Response to Planning application from Hertfordshire County Council (T and CP GDP Order 2015)

District ref: 6/2020/1837/FULL
HCC ref: WH/2947/2020
HCC received: 10 August 2020
Area manager: Alan Story
Case officer: Paul Marshall

54 BRIDGE ROAD WELWYN GARDEN CITY AL8 6UR

Erection of 1x dwellinghouse following demolition of existing house

Drawing Number:
IND-754-P20

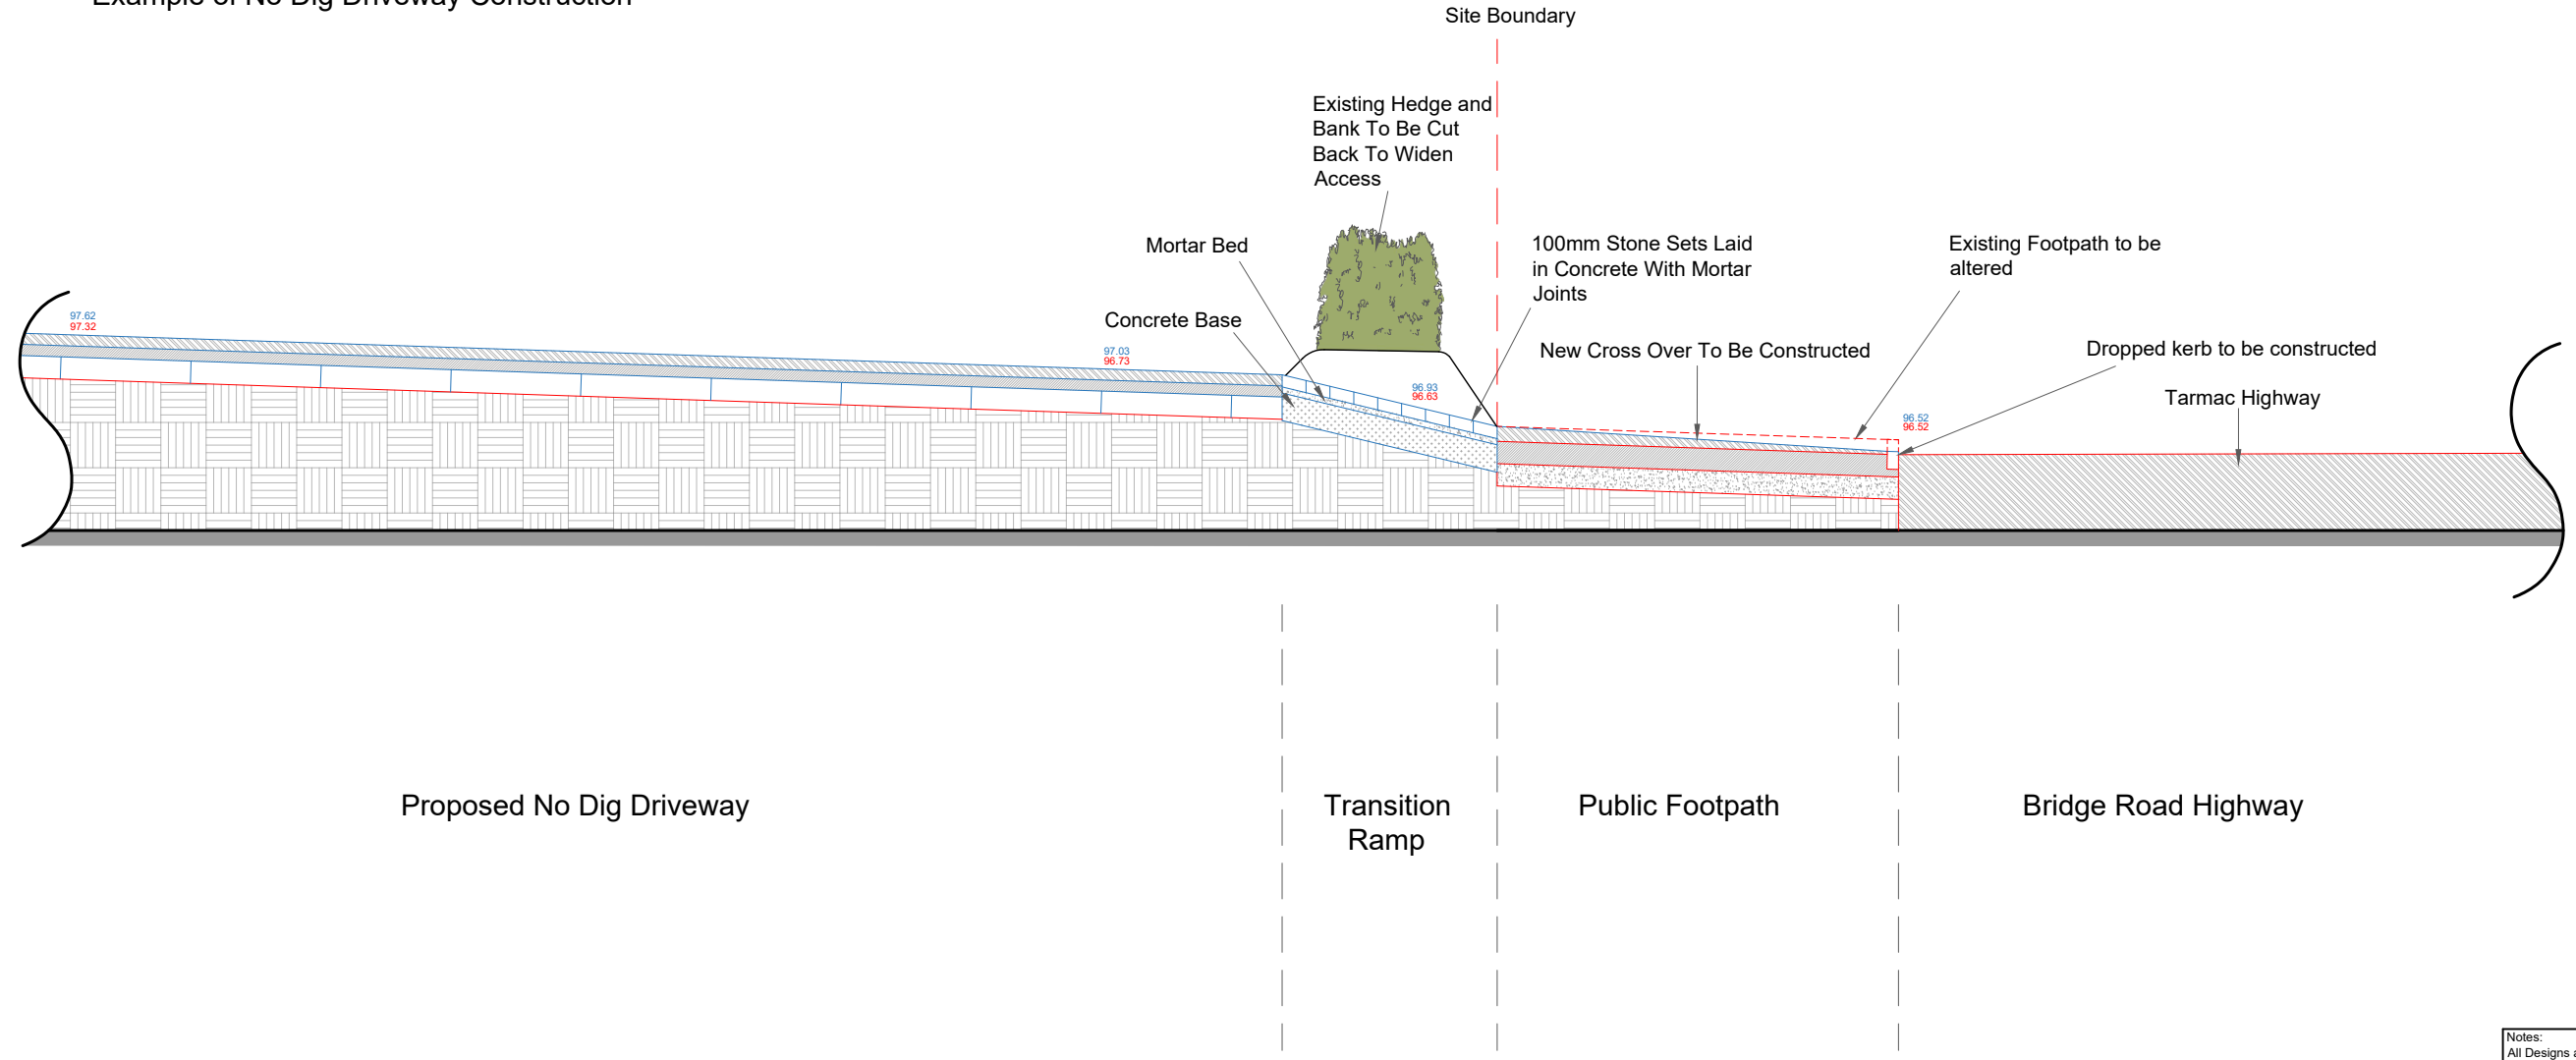
Con1) The gradient of the vehicular access shall not exceed or 1:10 for the first 5 metres into the site as measured from the near channel edge of the adjacent carriageway.

Drawing IND-754-P01 demonstrates the width of the access road to be 3.0m to the parking area which is acceptable for a shared surface. The proposed driveway should be of a bound material to reduce the risk of loose surface dressings entering the highway.
